Elm Tree House
Church Lane
Wendlebury
OX25 2PN

19/01005/F

Proposal: Internal and external alterations to the house and garage

DRAWING TITLE  
**Proposed garage elevations**

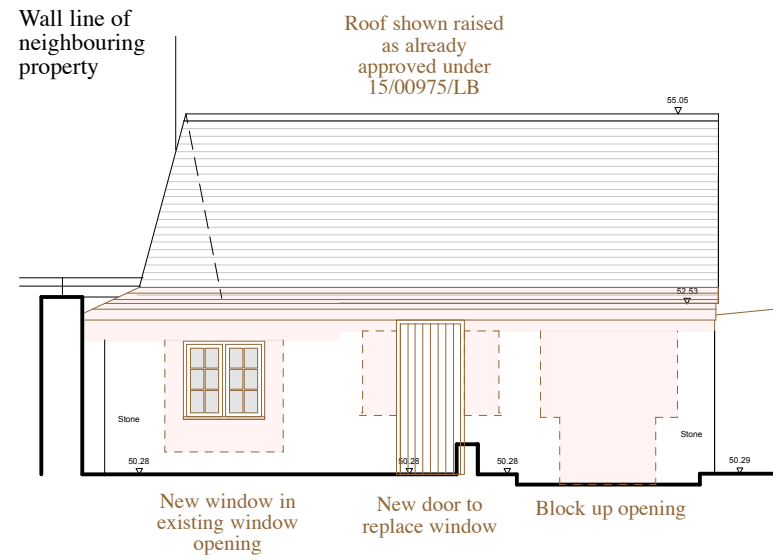
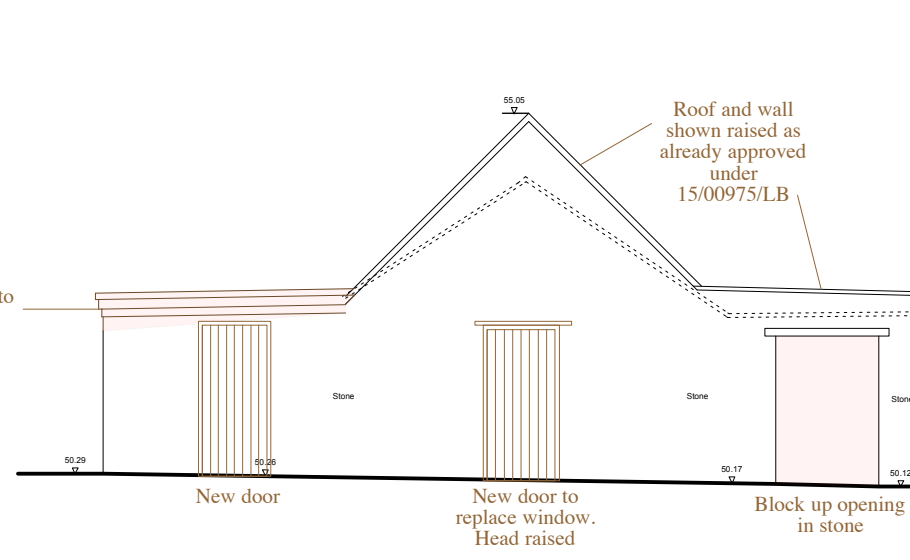
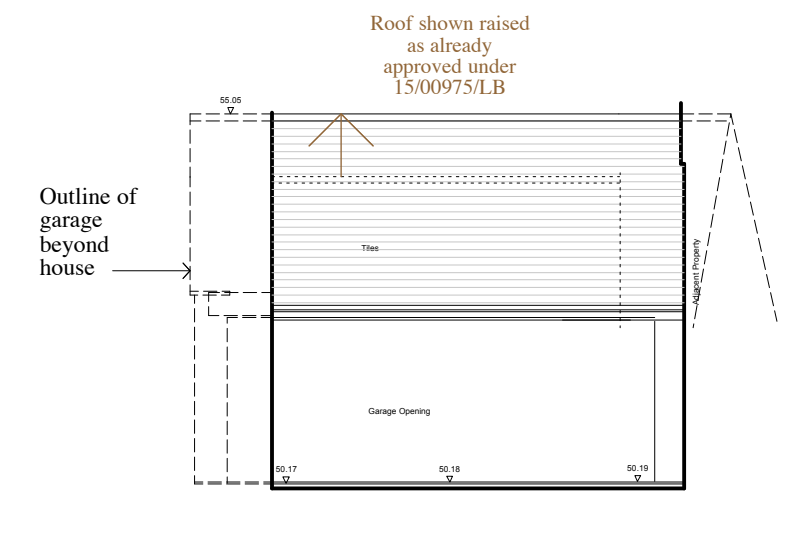
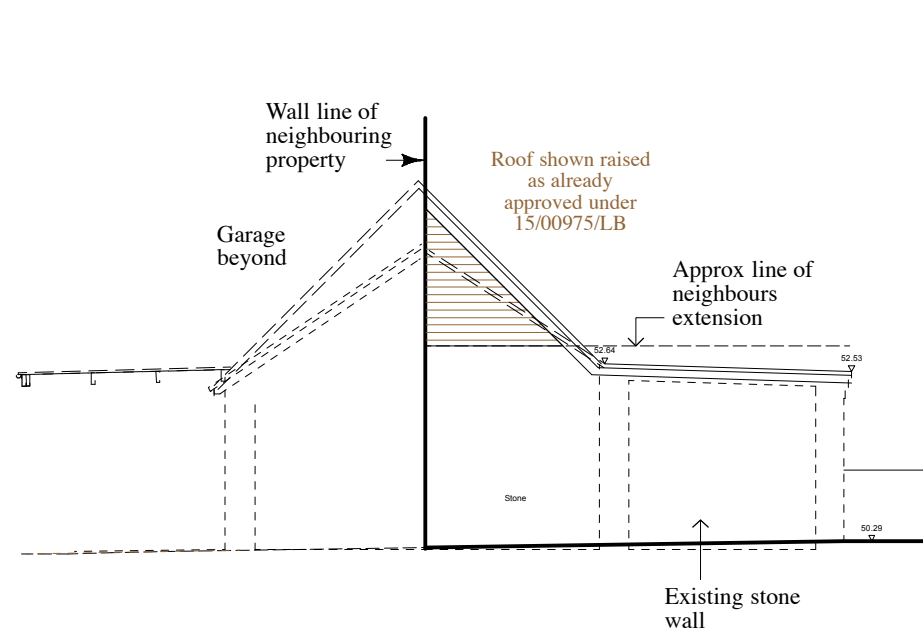
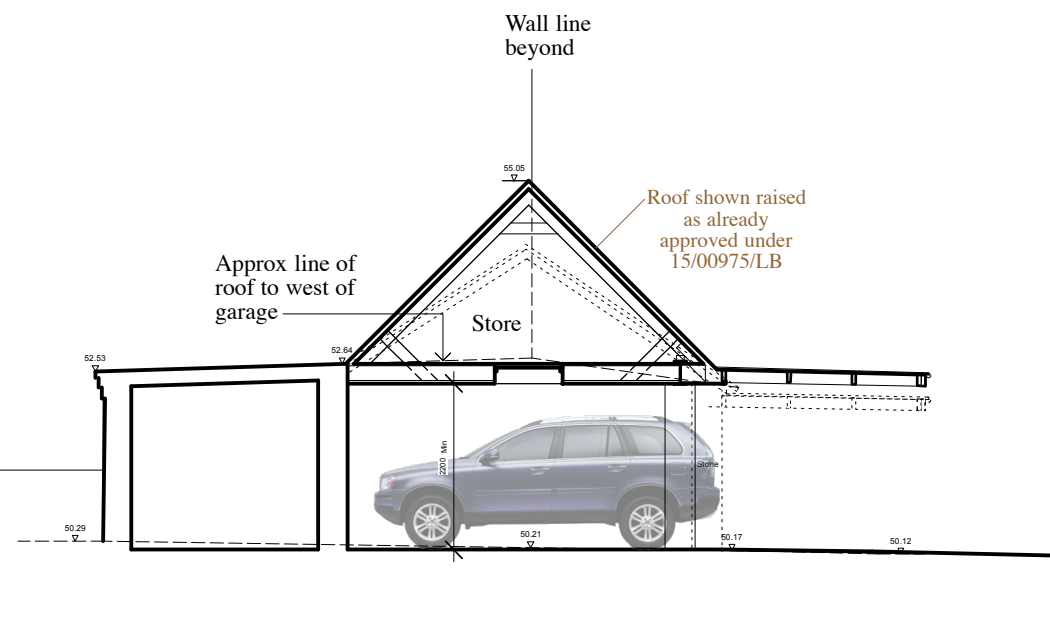
- 8.13. The neighbours to the east of the site, The Laurels, are attached to the garage which is proposed to be altered by increasing the height of the pitched roof. The closest section of the side elevation of this neighbour has no windows however there is a window located further forwards on the gable end side section. Given the orientation of the properties and the fact the roof will only be raised by approximately 0.8 metres it is, however, unlikely there would be any detrimental impacts on light, outlook or privacy. The rear elevation of this neighbour only has a flue that is close to the boundary with the closest window being set away. As this is the case, and the fact they also benefit from a single storey rear extension of a similar height to the level the flat roof section to the rear of the pitched section of the garage would be increased to, it is therefore unlikely there would be any detrimental impacts on light, outlook or privacy. It should also be noted that the same extension was previously approved in 2015; however, the permission has now lapsed.

DRAWING TITLE  
**Proposed first floor plan**

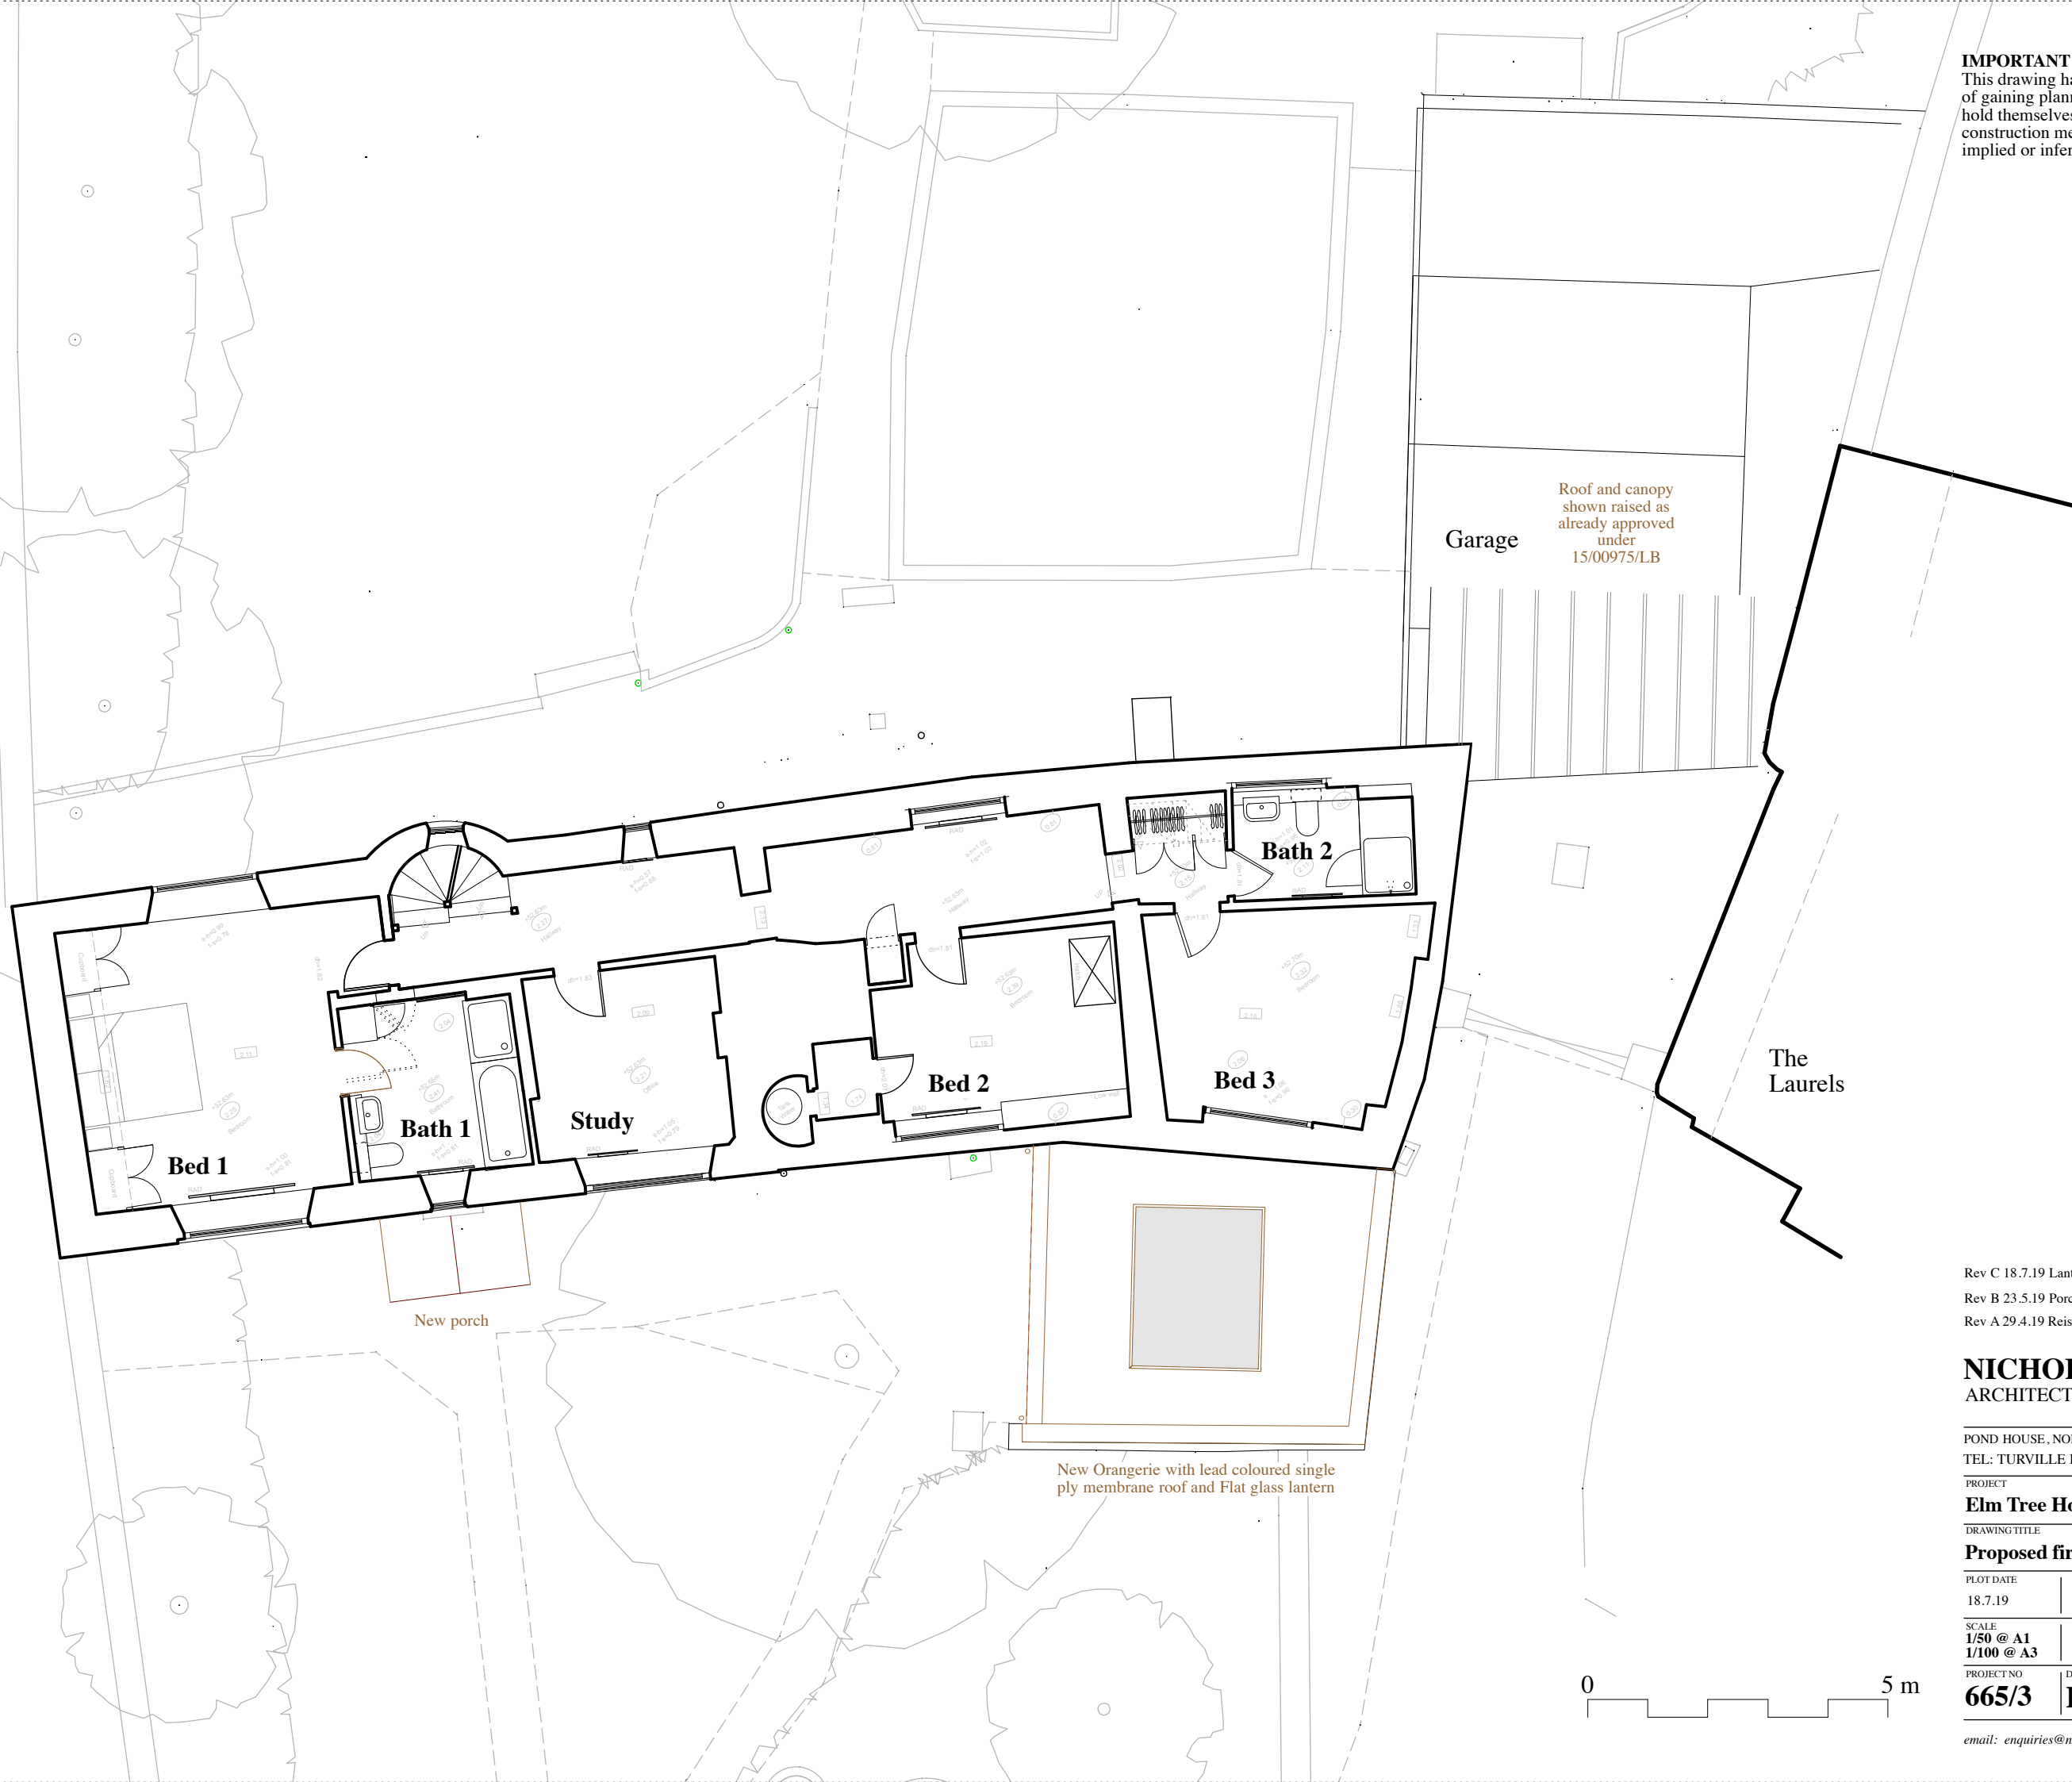
- 8.8. The proposals also include the alteration of the existing utility area to create a garden room. Concerns were raised about the visual appearance of this due to the roof lantern that would be visible above the proposed parapet. Amended plans have been received that now include a flat roof lantern which would not be visible. This is welcomed as it is considered that it would maintain the appearance of the building from the important front elevation, as well as ensuring the proposal does not harm the character of the surrounding area due to its prominence in the streetscene. Most of the fabric to be removed in this area of the building is modern fabric however there is one internal wall to be removed that is believed to be a historic wall to a pigsty that was located here historically. This wall although historic fabric is not considered to contribute to the significance of the building and the Conservation Officer advises that therefore on balance its removal would be appropriate in heritage terms.
